APPLICATION BY HIGHWAYS ENGLAND FOR AN ORDER GRANTING DEVELOPMENT CONSENT FOR THE A303 SPARKFORD TO ILCHESTER DUALLING

SUBMISSION MADE PURSUANT TO DEADLINE 7

South Somerset District Council Submission - Deadline 7

The following comments are submitted by South Somerset District Council in response to documents submitted at deadlines 6 and 6a.

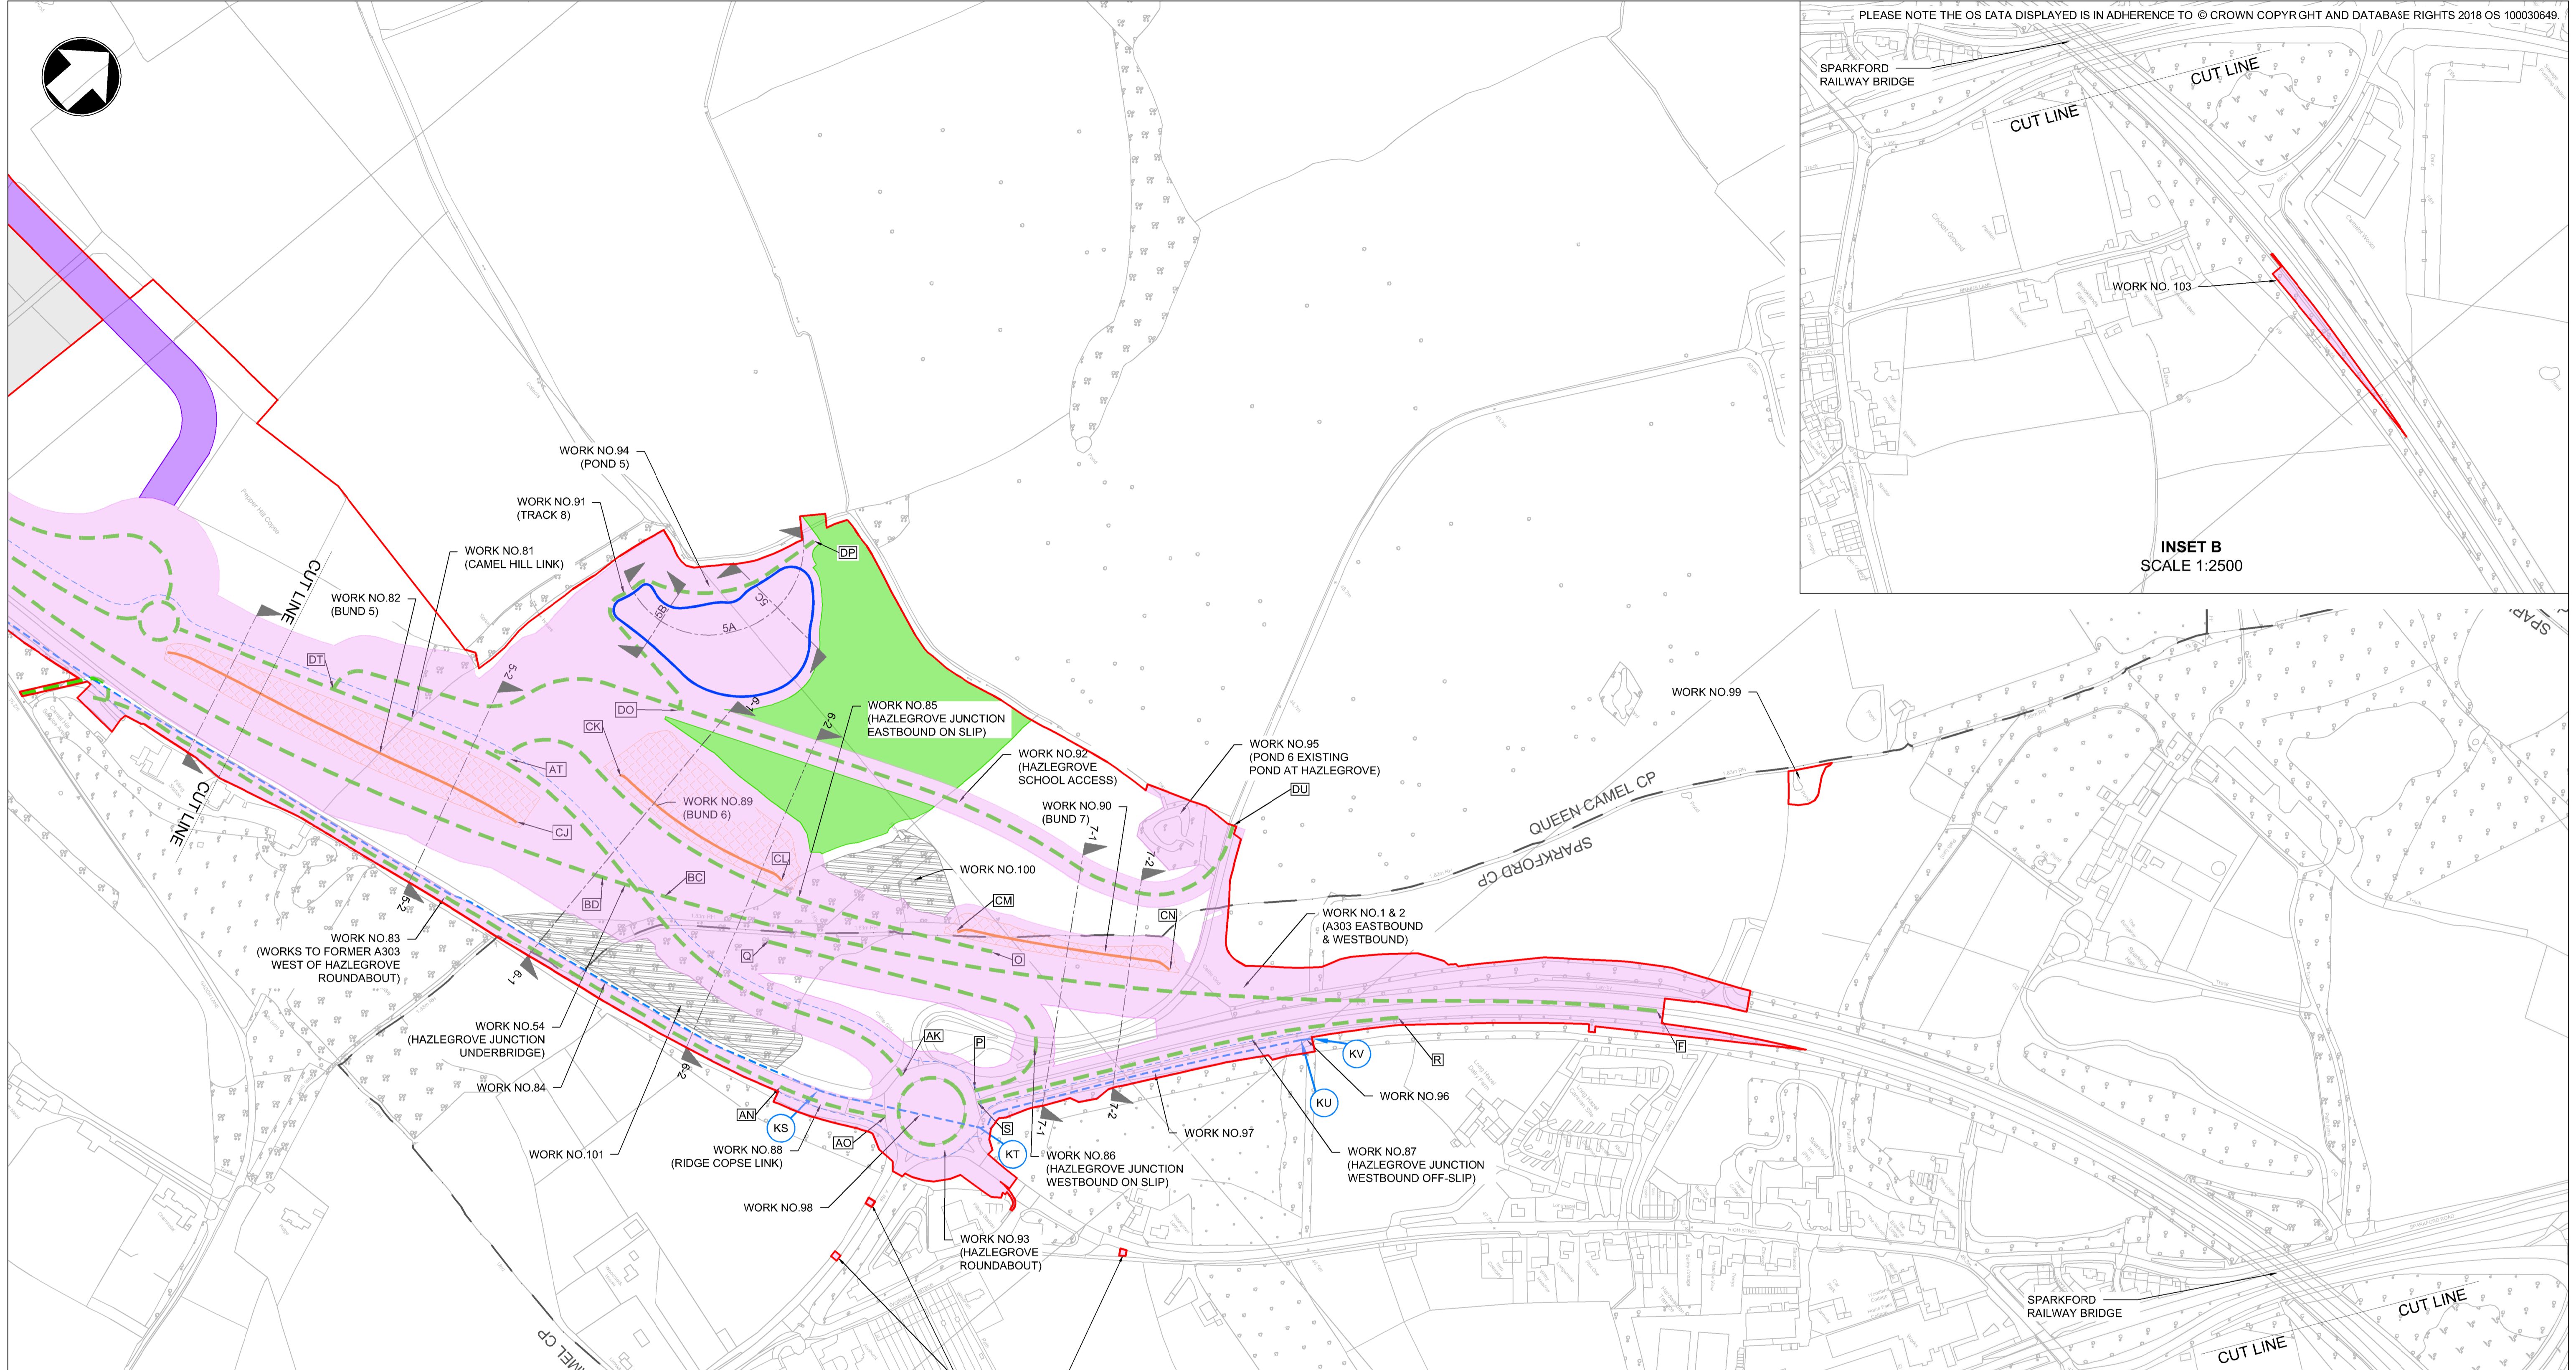
Sheet 4 of 4, which covers the south-west corner of the RPG affected by the non-material amendment, and the amendment concur with the proposal in the non-material amendment and the lateral limits of deviation for the amended driveway alignment is accepted.
